Our Reference: PF: 5007.190P2  
Your reference: SSD 8640

14 June 2018

**PICTON HIGH SCHOOL REDEVELOPMENT  
480 ARGYLE STREET, PICTON (SSD 8640)**

APPROACH | TREE RETENTION + REMOVAL STRATEGY

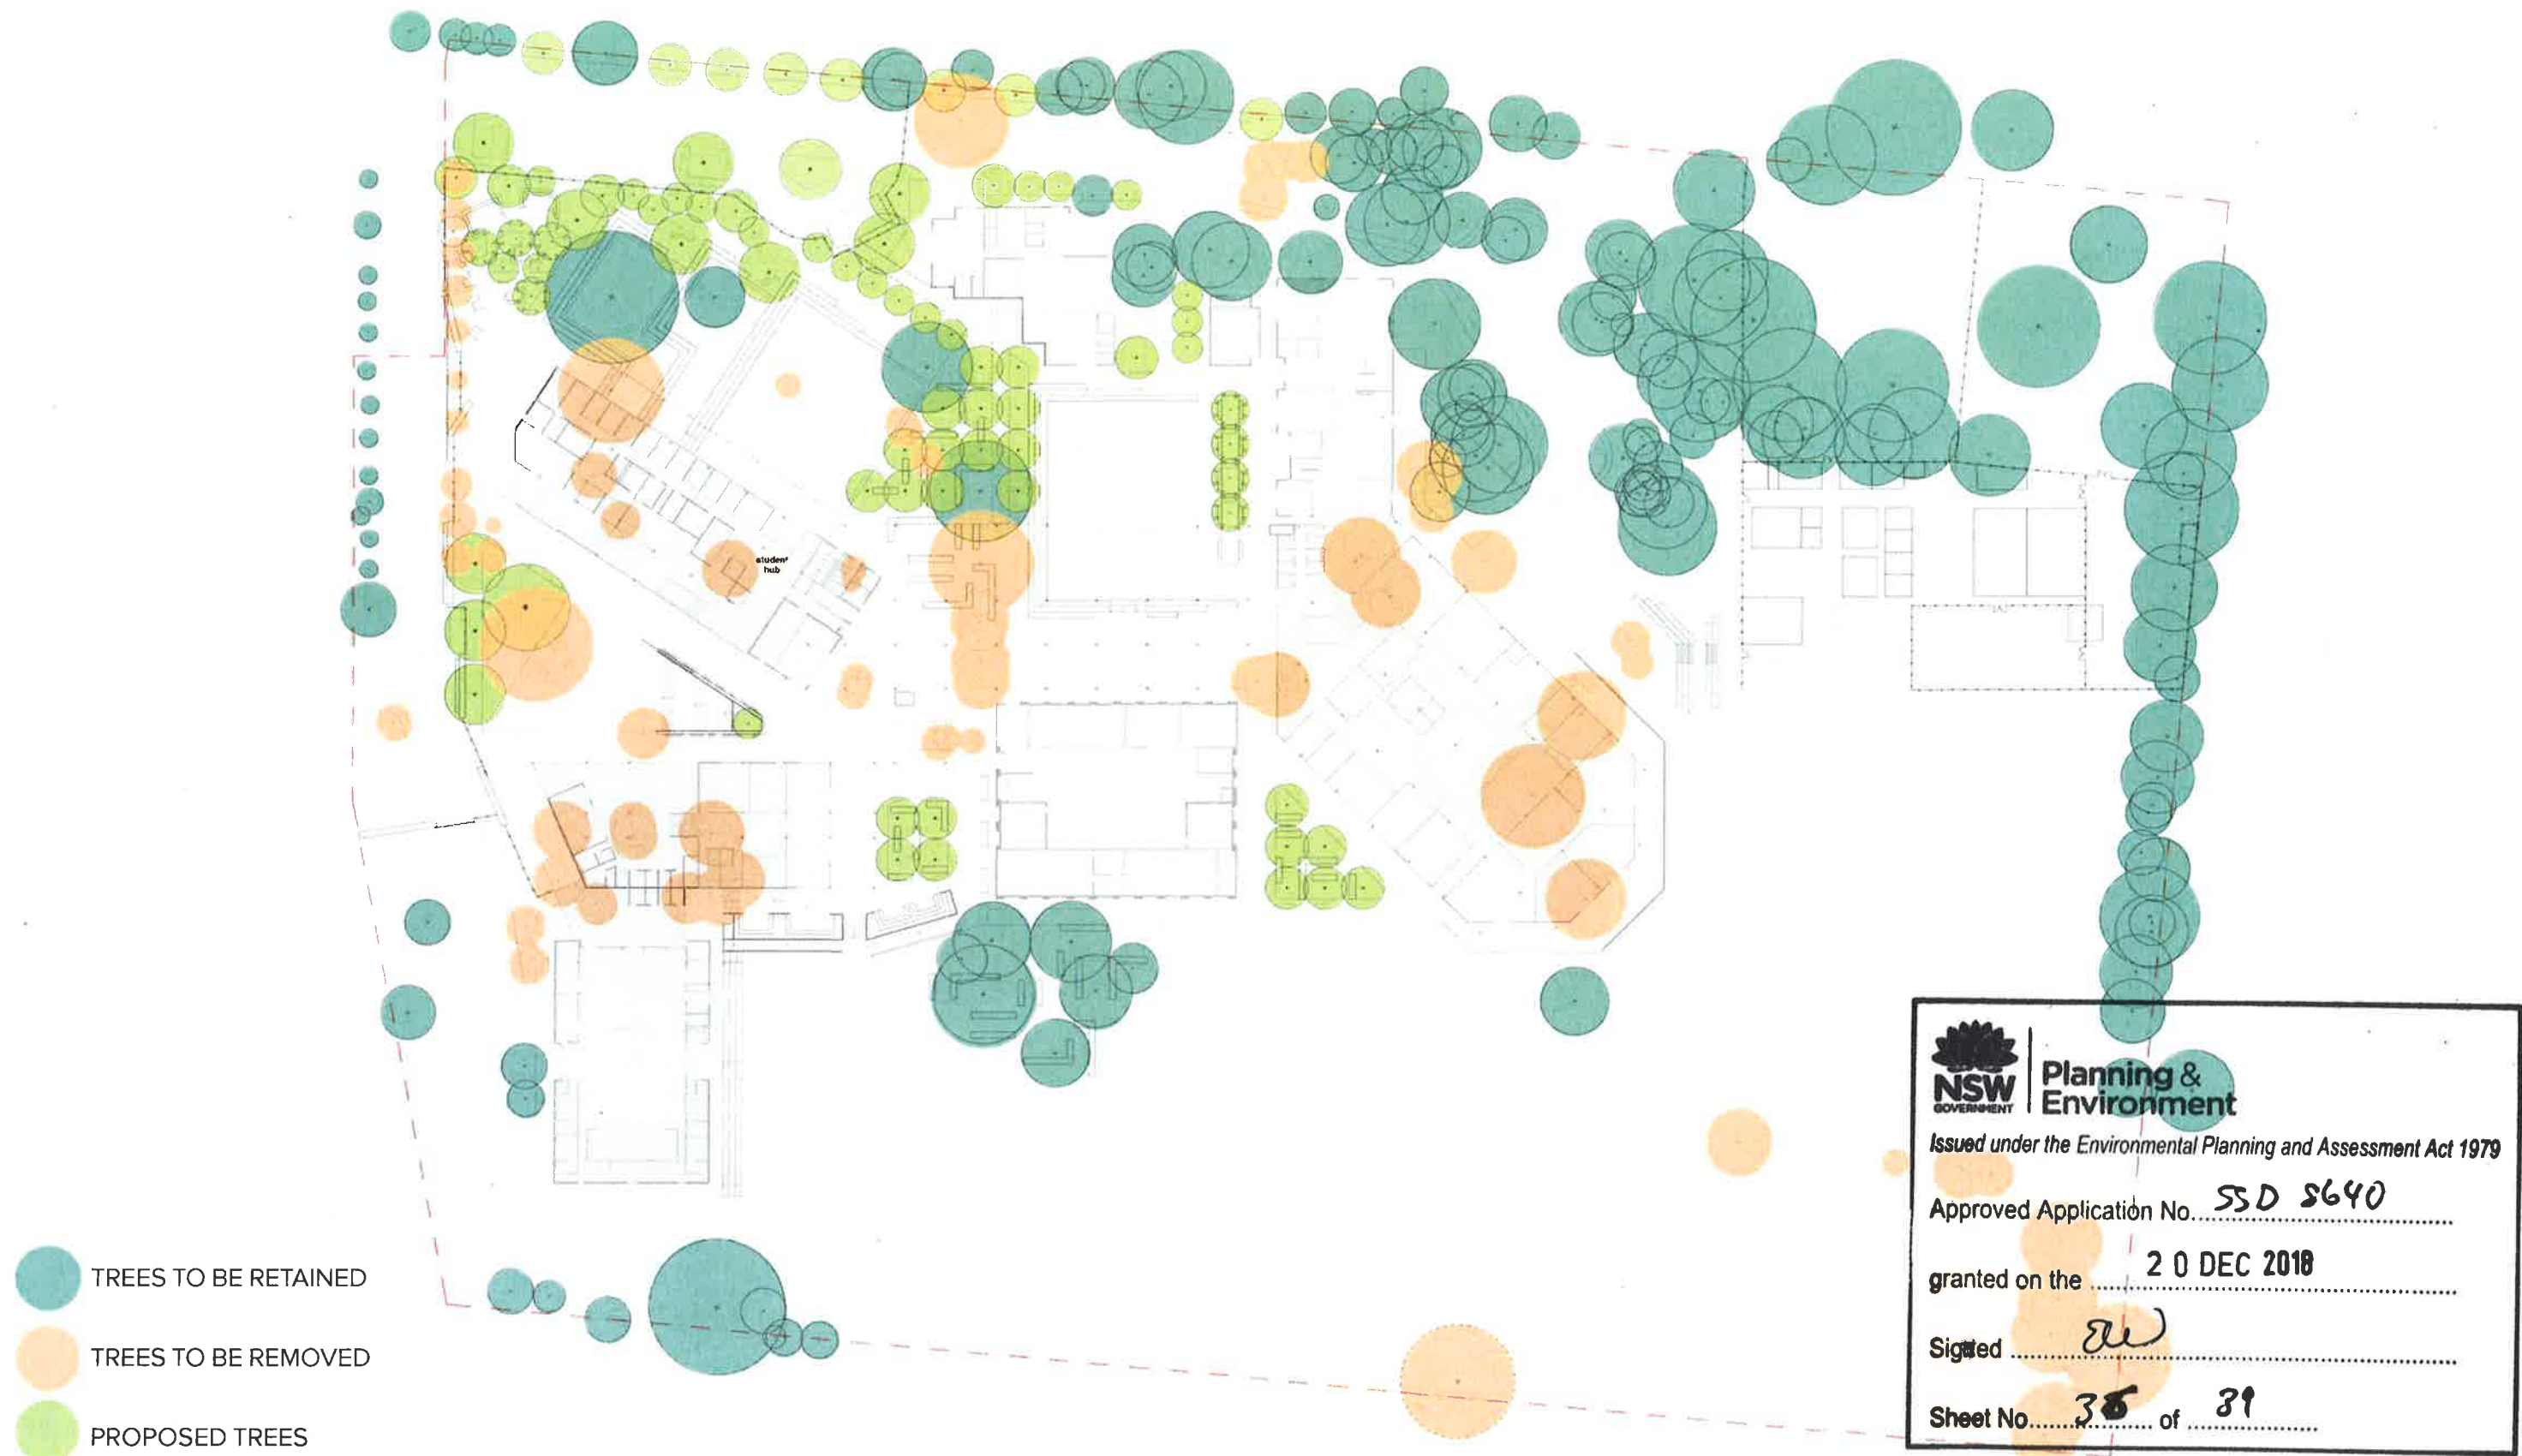
The Tree Identification Assessment Summary lists 78 trees for removal. We believe the DA approval should be on the basis of minimizing the removal of trees on the site.

Council recommend that the following listed trees NOT be removed:

- Tree 14 Himalayan Cedar at the front of the site. Council disagrees with the "Low" rating in relation to Landscape/ Visual Significance. The tree is prominent in the location for persons living near and passing the site. It appears to be one of the oldest trees on the site and has cultural significance as part of the memorial garden;
- Council does not support the removal of trees 46 to 53 which are outside the new building zone;

- If an apparently enlarged sports field greyed out on page 67 is not part of the DA we query the need to remove trees 68 to 73;
- Council also queries the need to remove tree 65.

We believe there should be no net reduction on the overall school tree canopy, i.e. replacement of all removed trees. We note that the report on page 2 refers to some out-of-date legislation.
